## Application for a Non-Material Amendment Following a Grant of Planning Permission

Partial demolition of existing barn and demolition of adjoining garage and erection of new extension to barn to form garage / workshop with hobby room over plus erection of adjoining garden room including access to hobby room, together with alterations and improvements to access and parking area.

21/0525/HOUS

It is now intended not to demolish the original 2 storey portion of the barn structure nor the single storey adjacent garage structure. It is now proposed to re use both structures, with repairs to barn gable end (insertion of new steel) reduction in wall height by removing top 3 / 4 courses of brickwork to form stepped ridgeline from neighbours portion of barn, reinstate stepped eaves course detail. Install new timber roof structure and replace original tiles where possible or replace to match to reflect original approved application. Windows, doors, in black aluminium along with black wood effect cementitious plank cladding as per original application with existing brickwork forming brick plinth feature as original application. (See attached Drg 0209-44 for new elevation / plan details)

PROJECT	DRG No	ALTERATIONS	ALTERATIONS	BY	BY
SCALE	SCALE	REV	REV	REV	REV
DATE	DATE	DATE	DATE	DATE	DATE
DESCRIPTION	DESCRIPTION	DESCRIPTION	DESCRIPTION	DESCRIPTION	DESCRIPTION
Barn Conversion & Parking	0209-44				
<b>BUILD</b>	As Noted @ A1				
MINIMUM BUILD	11-1-2024				
<b>PROPOSAL</b>	DWN BY

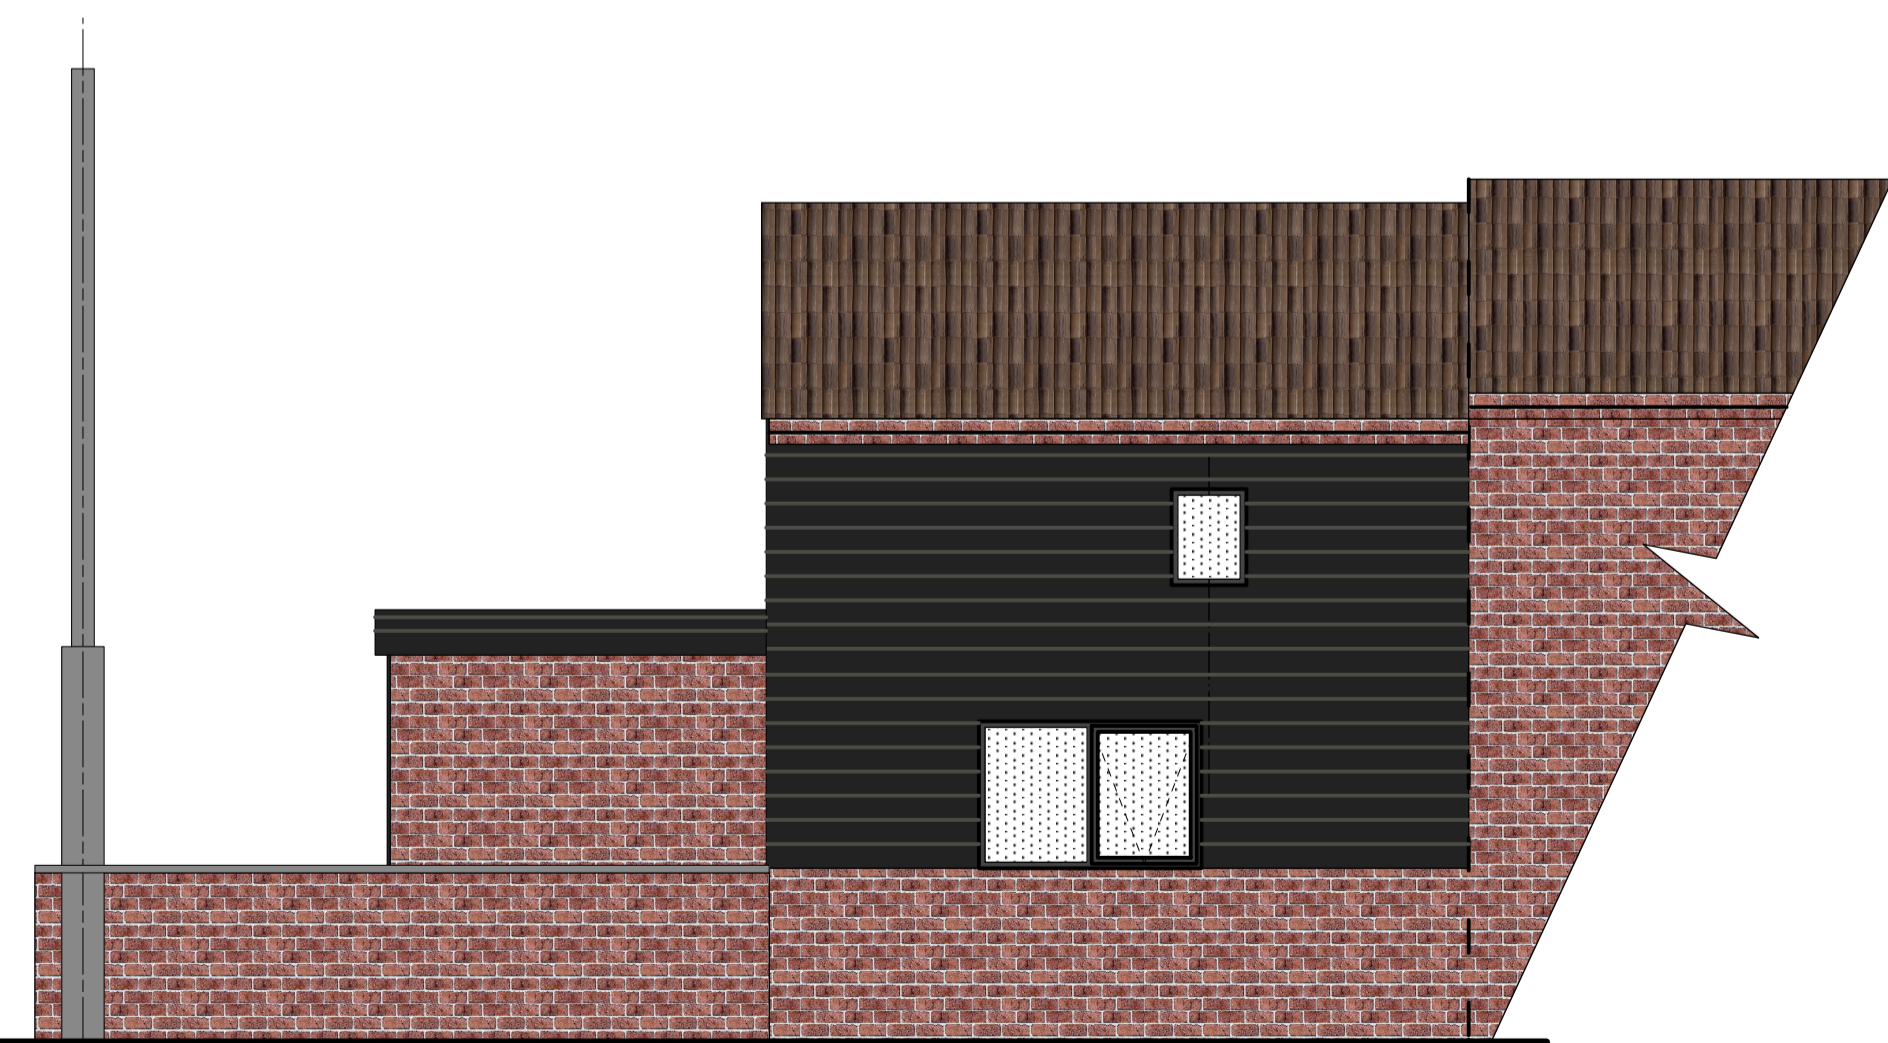
Existing adjacent garage structure to be partially demolished, with new additional brick / block infills to existing openings to match materials and design scheme of original application and barn alterations. (Doors / windows / cladding - new flat roof)
